Current Zoning: B-1(CD) (neighborhood business, conditional)  
Proposed Zoning: MUDD (CD) (mixed use development, conditional)

Approximately 0.86 acres located in the northwest quadrant of the intersection of Park Road and East Woodlawn Road, south of Drexel Place.

The petition proposes to allow the development of a retail and EDEE uses on a parcel that is currently vacant.

Staff recommends approval of this petition upon resolution of an outstanding issue related to transportation and requested technical revisions.

INITIAL SUBMITTED REZONING PLAN

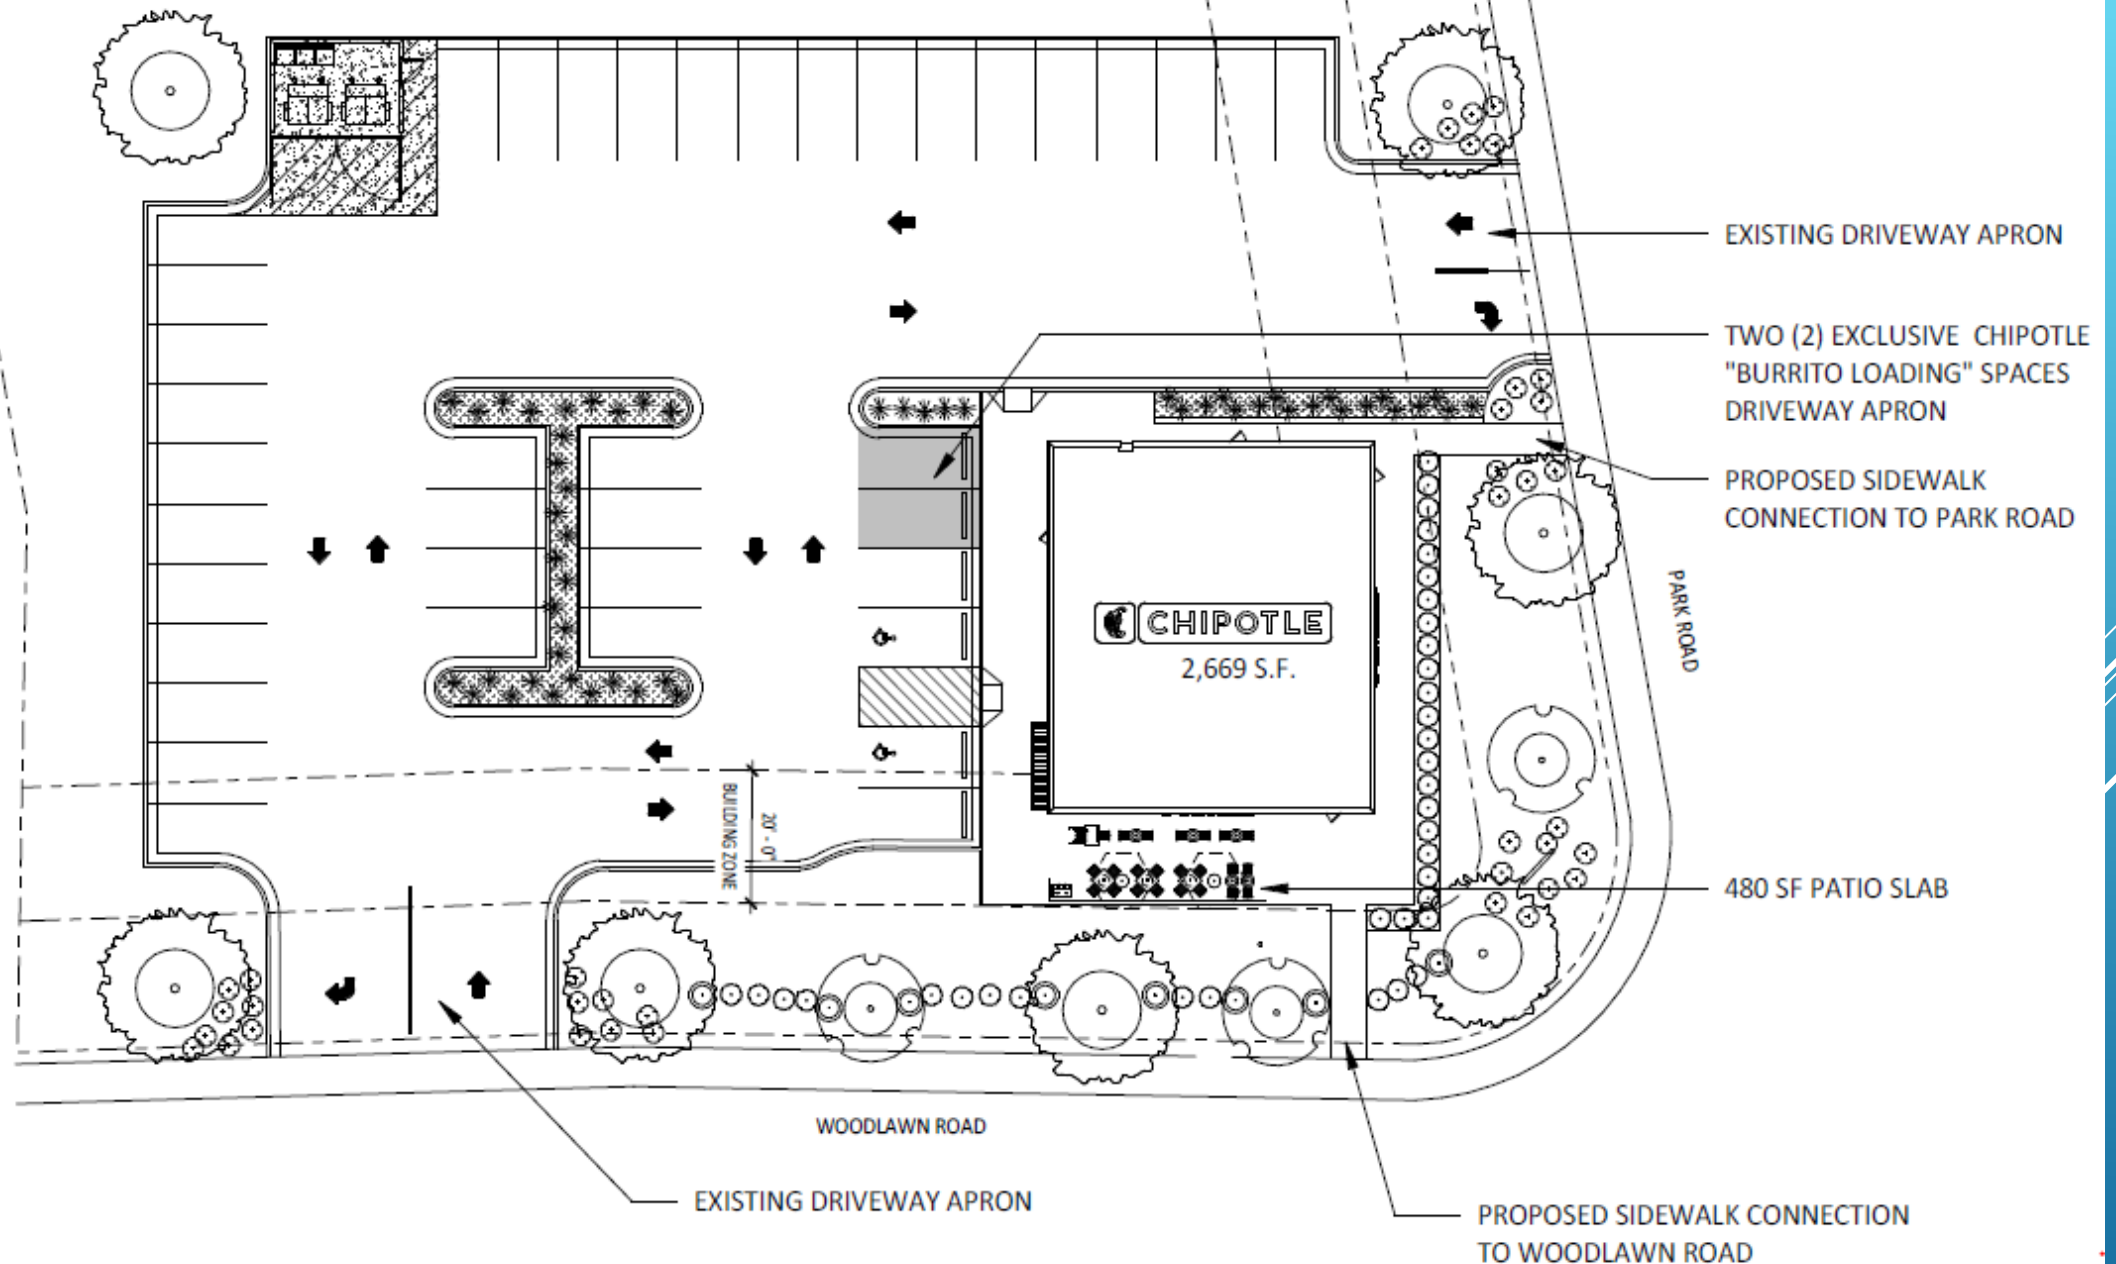
1. Revise site plan and conditional notes to reserve space to provide future dual left turn lanes on the eastbound approach of Woodlawn Road.

6. Revise conditional notes to commit to construct bicycle facilities on Park Road and Woodlawn Road by locating the curb and gutter 8' from the curb line established by Adler Montford Park (SDRMF-2022-00010).
- 7.
